Demolition of existing dwelling & erection of a 71 bedroom care home (C2 Residential Institution) with car park, landscaped gardens & access from Roundstone Lane. This application is a Departure from the Development Plan.

Pound Place Roundstone Lane Angmering

Thank you for your internet representation made on 14th May 2018 which has been recorded as '**an objection**' with the comments as follows:

**TREE PROTECTION PLAN**

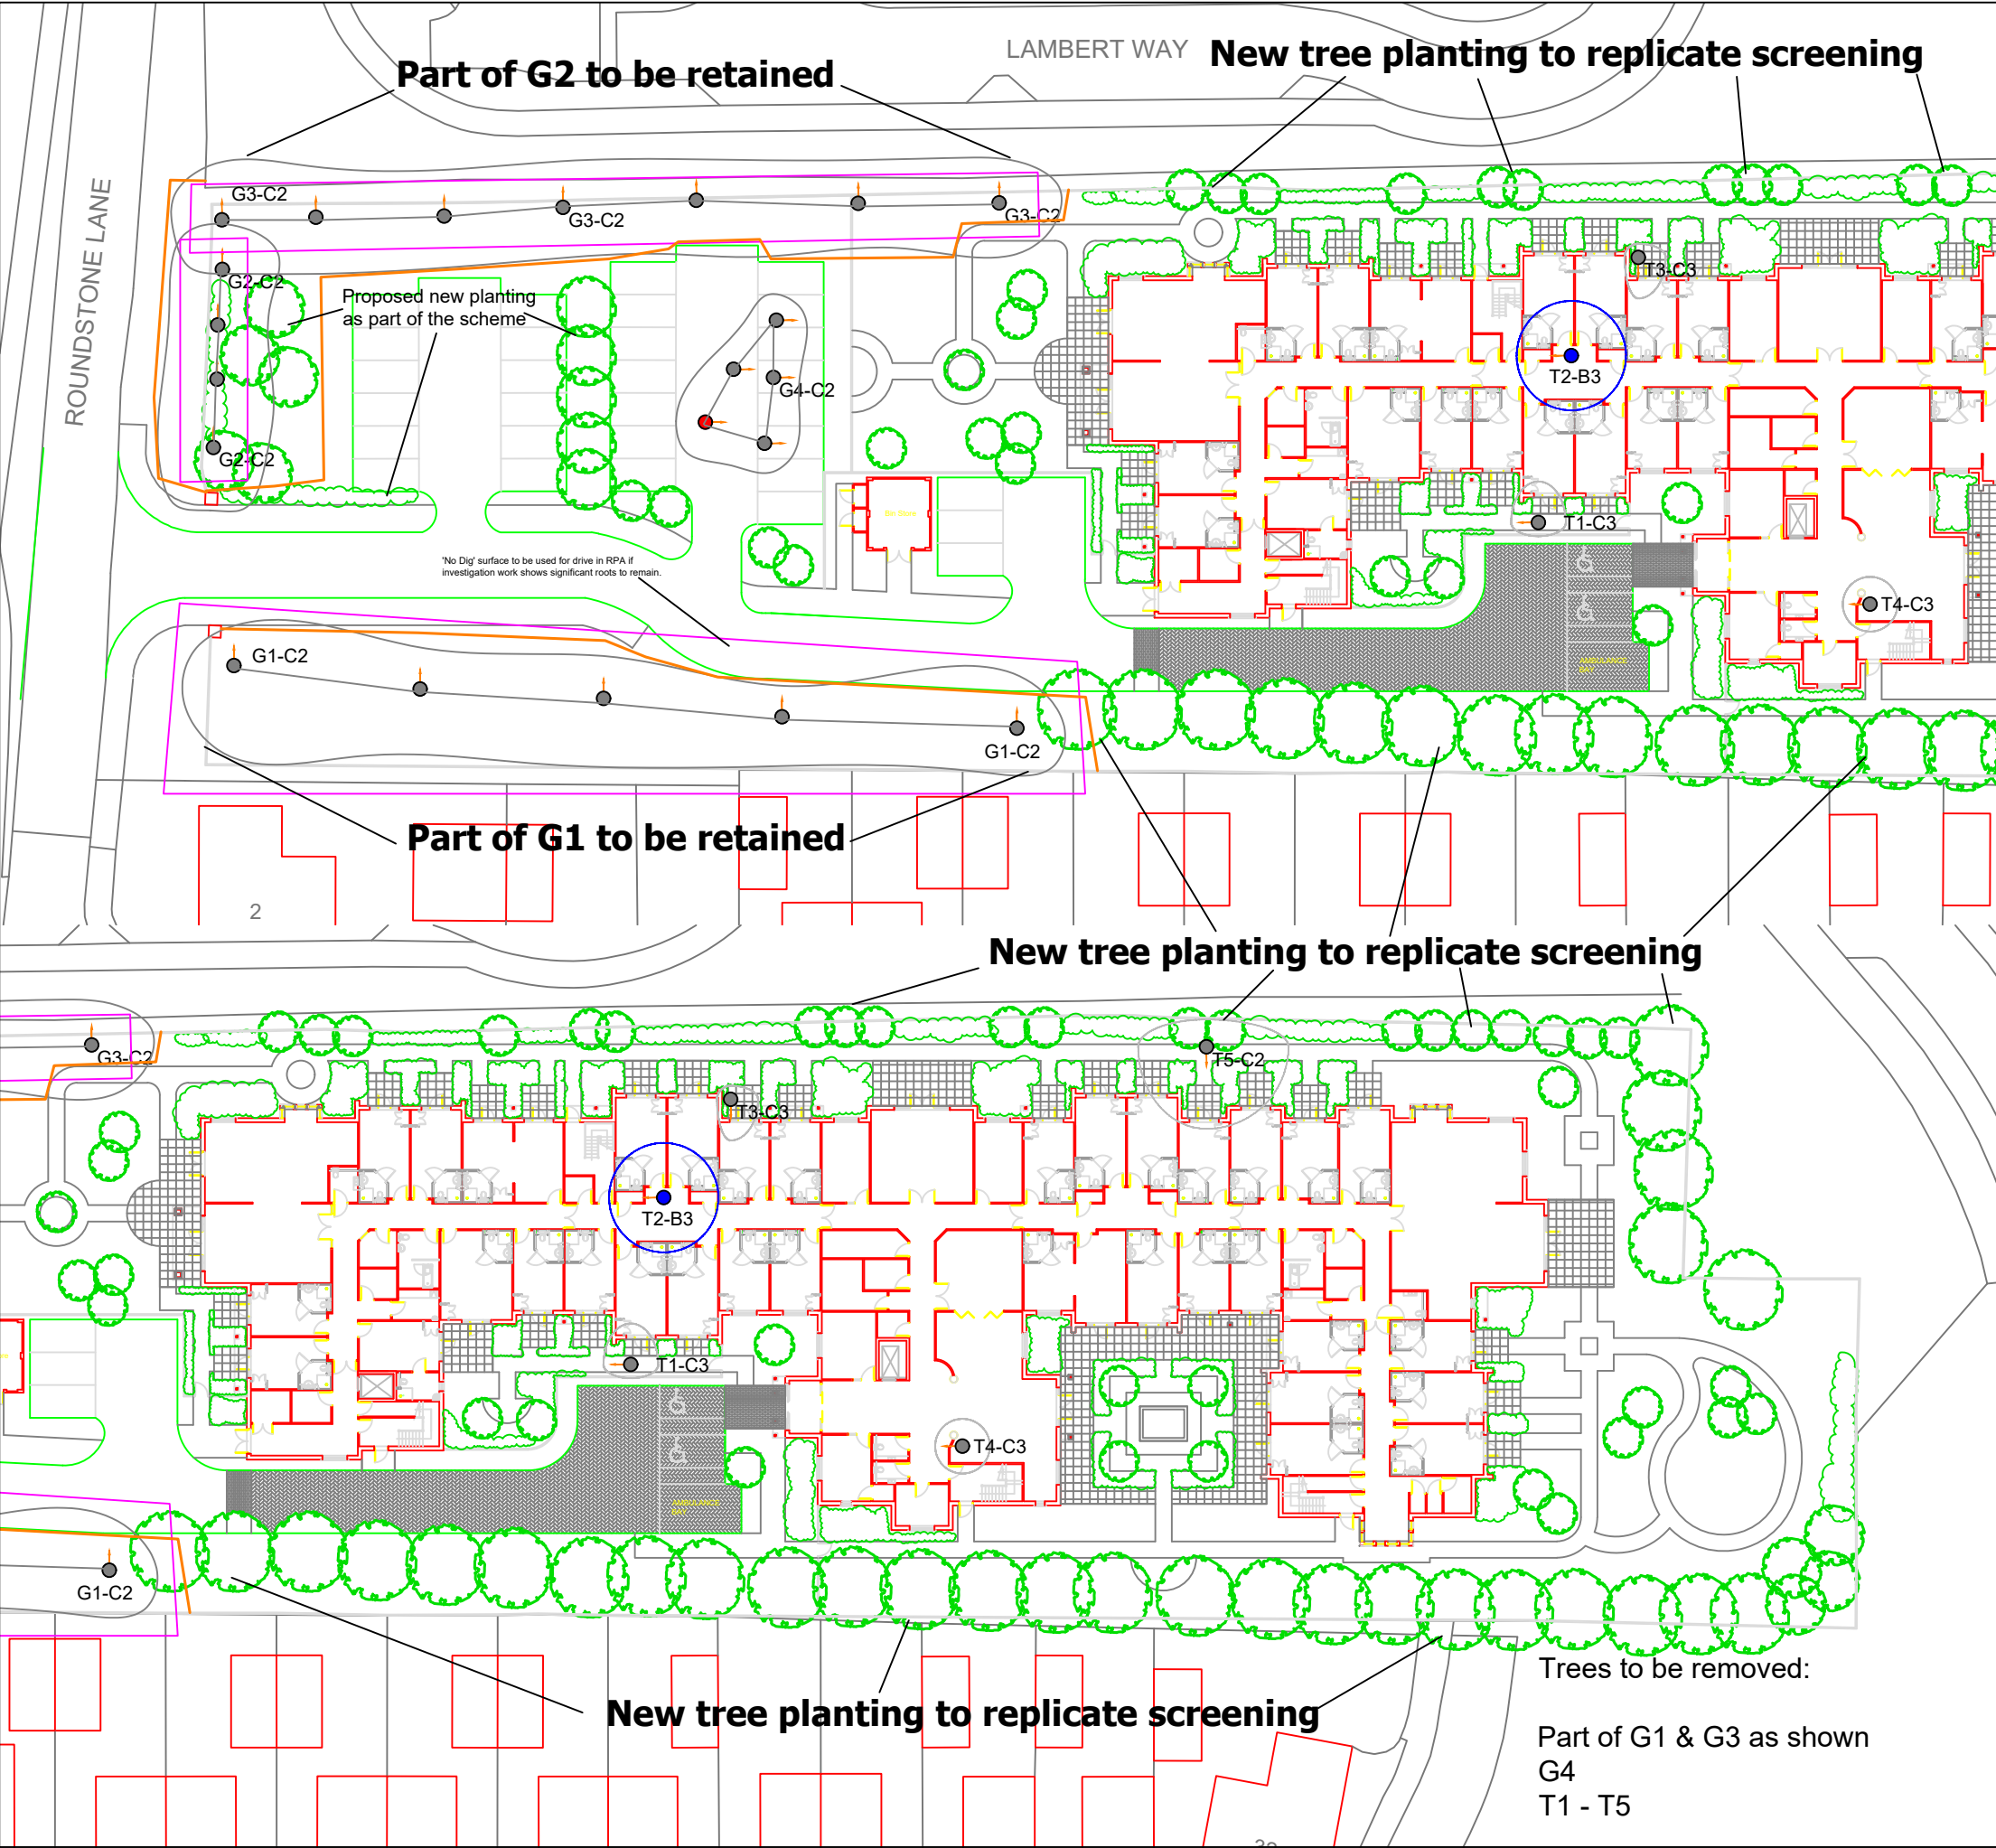
My objection is not against the development of the Care Home itself, rather against the removal of perfectly healthy trees that surround Pound Place.

The Leylandii provide essential screening both from Roundstone Lane and indeed in separating the developments of Swanbourne Park and the estate on the former Nursery that is now Broughham Grove. Without this screening, the whole area simply becomes one big development Estate with a consequential loss of rural amenity. The trees also provide a wonderful habitat for a thriving bird population whose habitat has been denuded by aggressive development of the area. The trees also have the capacity to support a sadly diminishing Bat population. Whilst this may not be their preferred habitat, because of the way these trees have grown, they do provide a vast array of crevices typically used by Bats. This can be readily seen by close examination in the evenings.

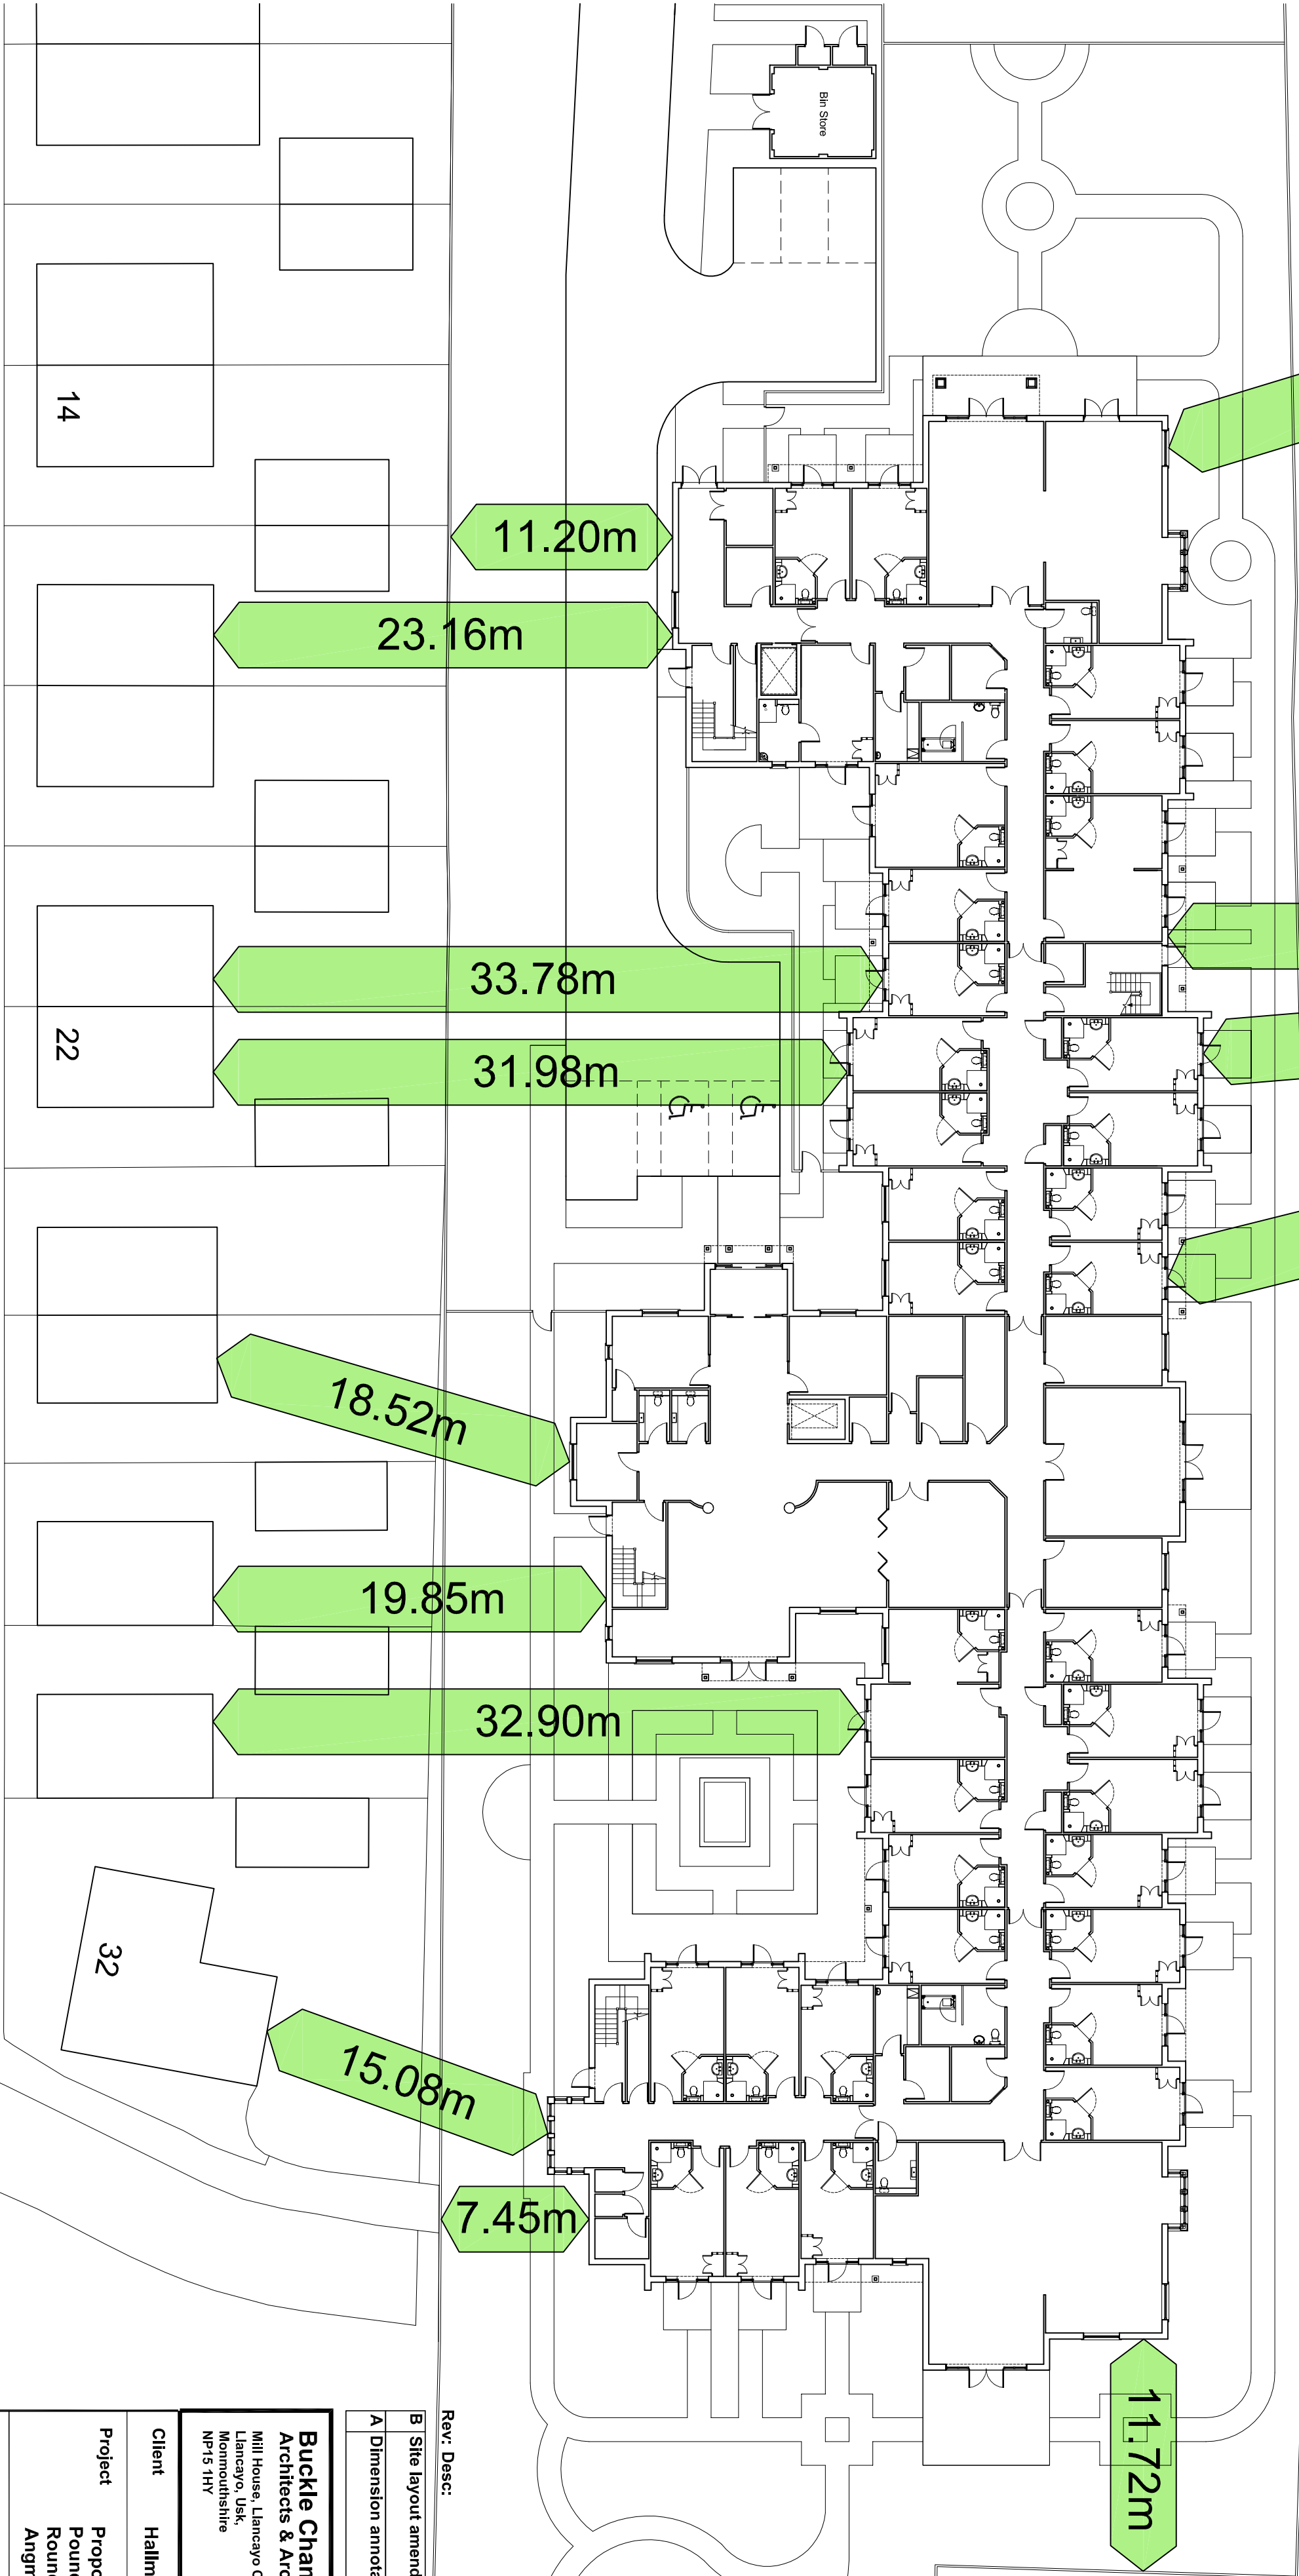
I also feel there would appear to be insufficient parking spaces on site. With staff working different shifts, often overlapping, additional spaces will be required rather than simply adhering to a notional formula.
